**SSD 6626 - SICEEP Darling Square - Mixed Use Residential
Building within North-East Plot**

SSD 6626 Submission

Concept proposal
parameter plan shadows
for N + SE plots

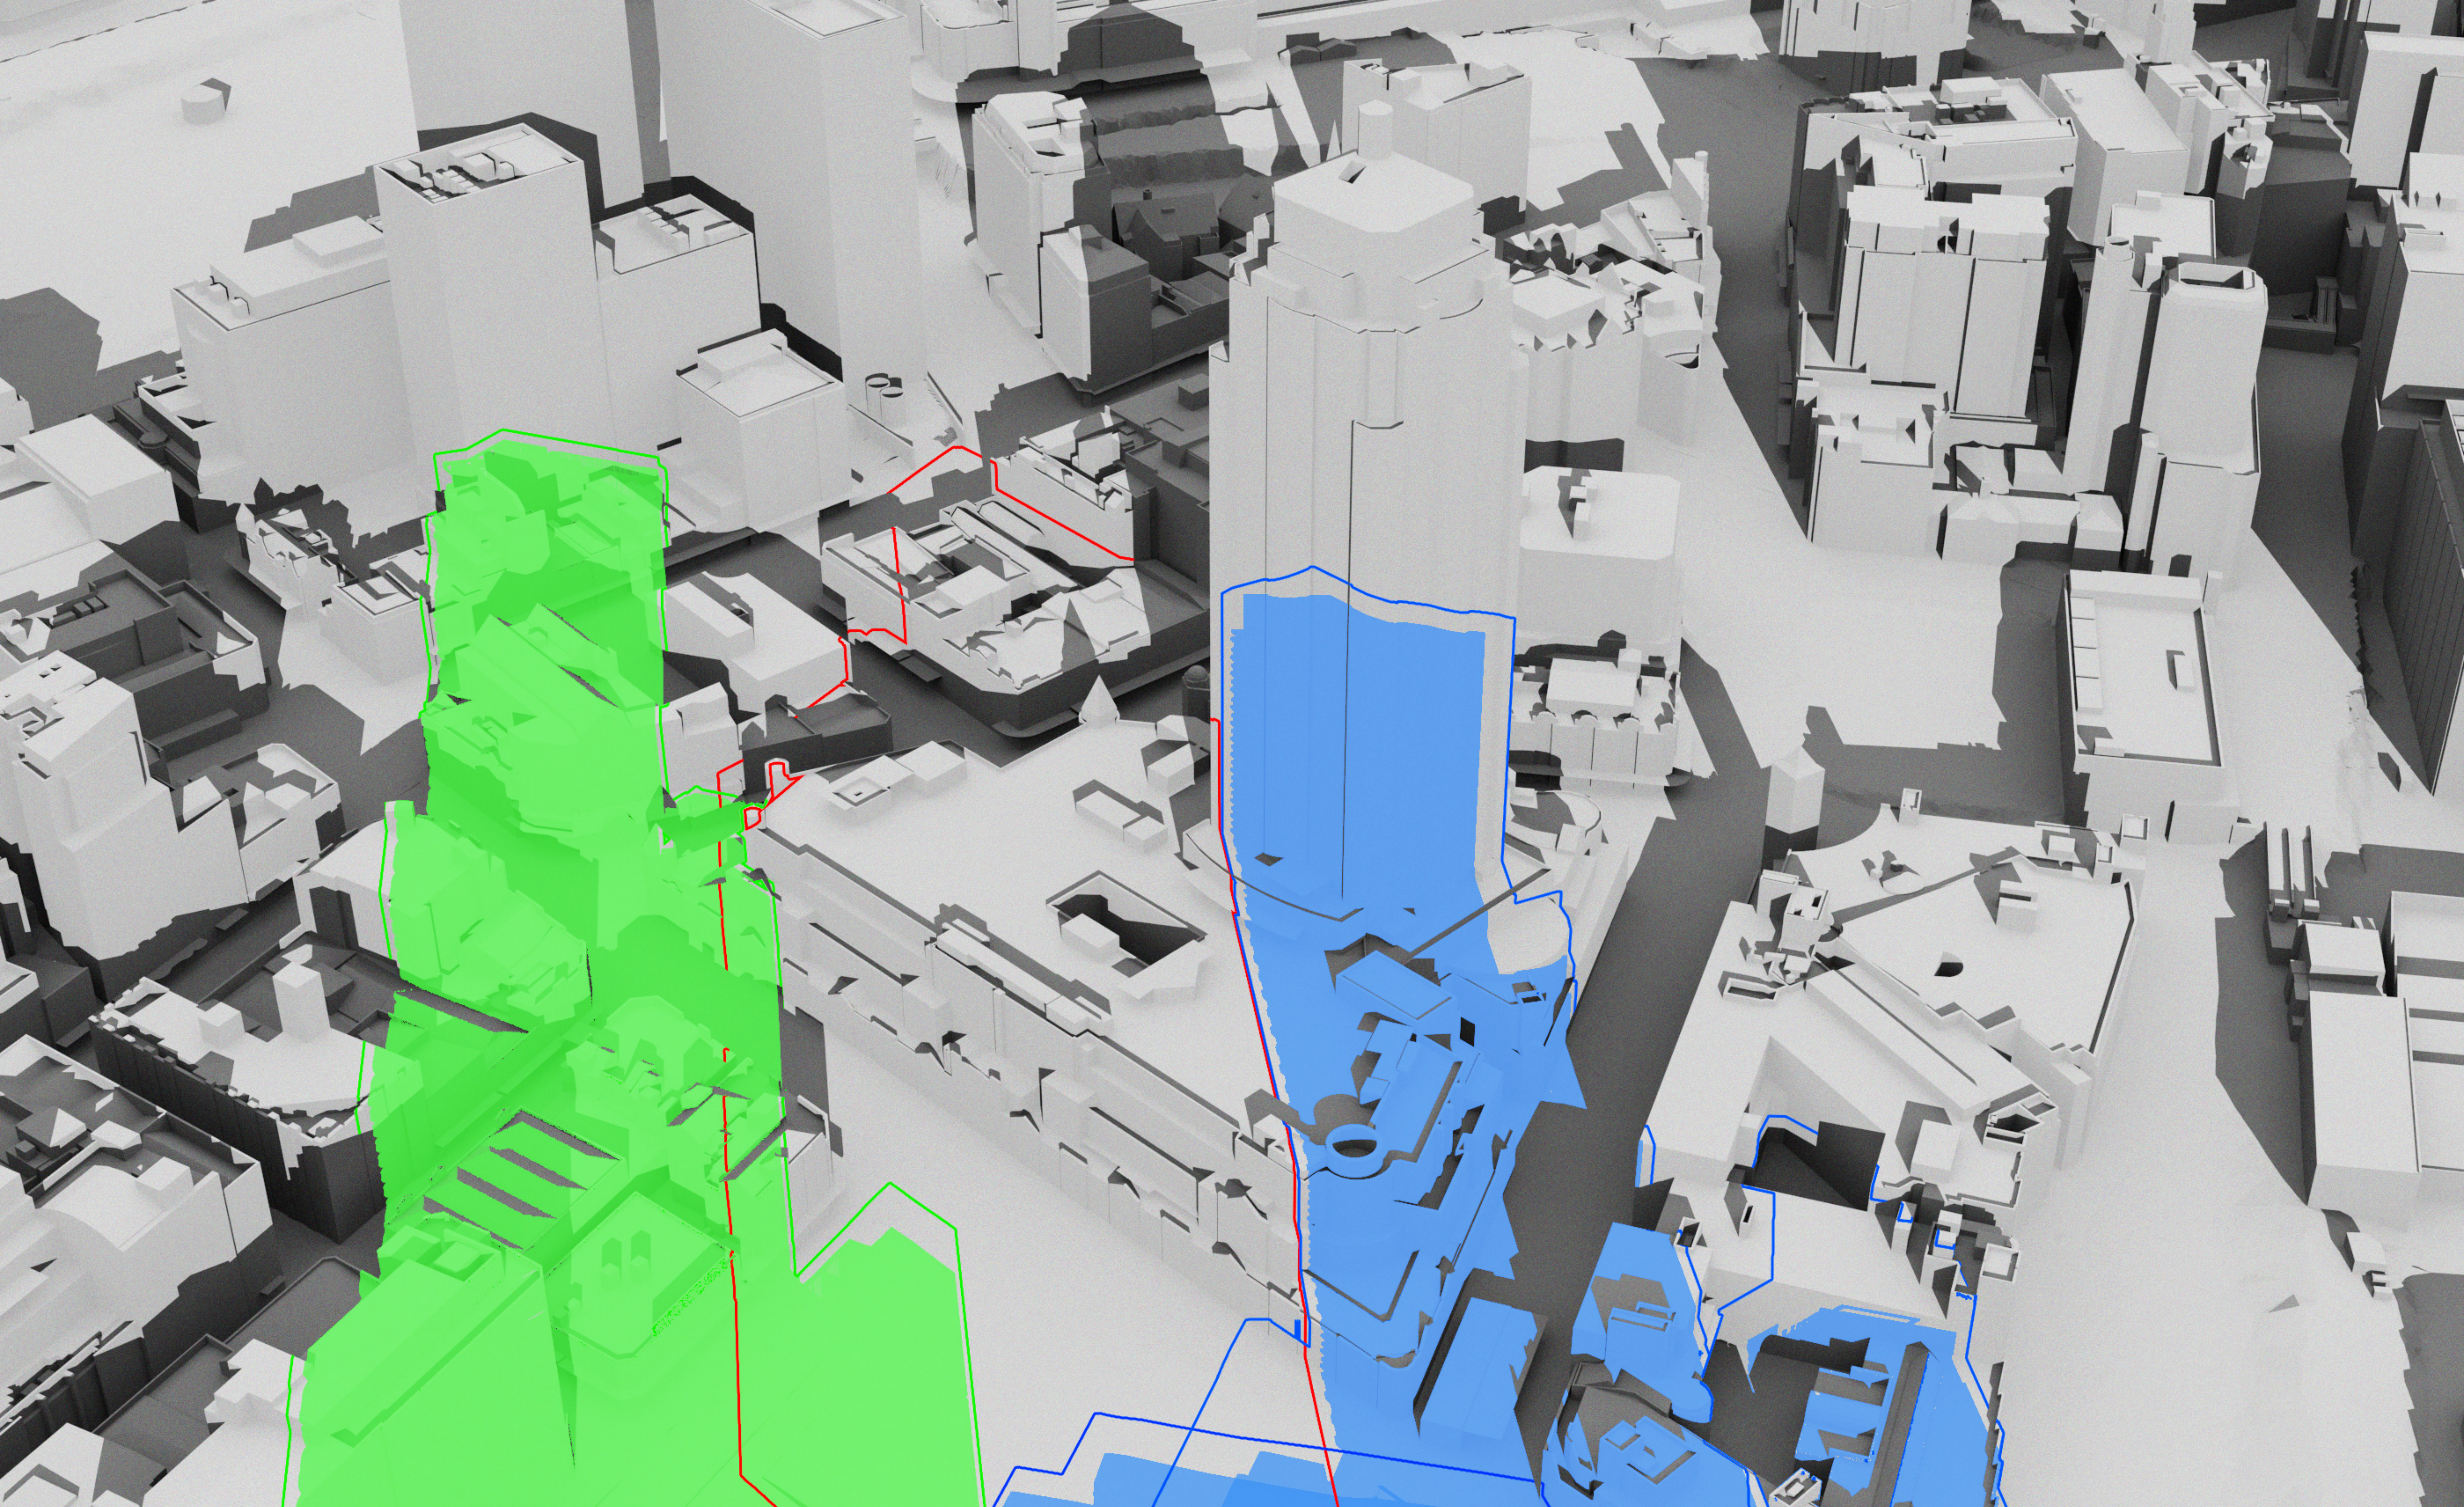
Excessive overshadowing of The Peak podium

With respect to the podium of The Peak Apartments, the EIS states that "The landscaped podium associated with The Peak Apartments will continue to receive at least two hours of solar access, ensuring compliance with the intent of the Sydney DCP 2012.". Although this statement is true, two hours is a major reduction from the existing 21 June daylight access of about six hours.

Excessive overshadowing of The Peak apartments

There is no overshadowing of apartments in The Peak by the NE plot. The overshadowing is by the SW plot being developed by the same proponent.

We take this opportunity to reiterate our submission on SSD 6011 (SW Plot) which stated "It can be concluded that, as a result of combination of the proposed (SW) development with existing shadowing of the west façade, some single aspect apartments on the west façade and the south-west dual aspect corner apartments which currently receive less than 2 hours direct sunlight to habitable rooms and 50% of the private open space between 9am and 3pm on 21 June will suffer additional overshadowing. " At the time of designing the development, the proponent was, despite having made numerous site visits, unaware that there were single aspect apartments in the Peak. The proponent now belatedly accepts that there are 110 apartments in the Peak which are single aspect west or north. The proponent's response to not meeting DCP overshadowing standards for those apartments was "The Sydney DCP does not apply to the SICEEP site." (SSD6011 South West Plot SSDA5, Response to Public Submissions, p2). Presumably the proponent will make the same response on any point where its standards fall below those of the Sydney DCP. And the consent authority is apparently not concerned by adopting standards below those of the Sydney DCP.

Excessive overshadowing of public open space - the new square - "Haymarket Square"

We agree with the City of Sydney's view that "excessive morning shadows are cast into the outdoor and café areas in the new square by new surrounding building edges. In order to improve morning sun access to the square in winter, it is recommended that the building heights lining the new square be reduced and the floor area relocated to the surrounding streets podium edges..." Source: City of Sydney, SSD 5878 (SICEEP) The Haymarket submission, page 34.
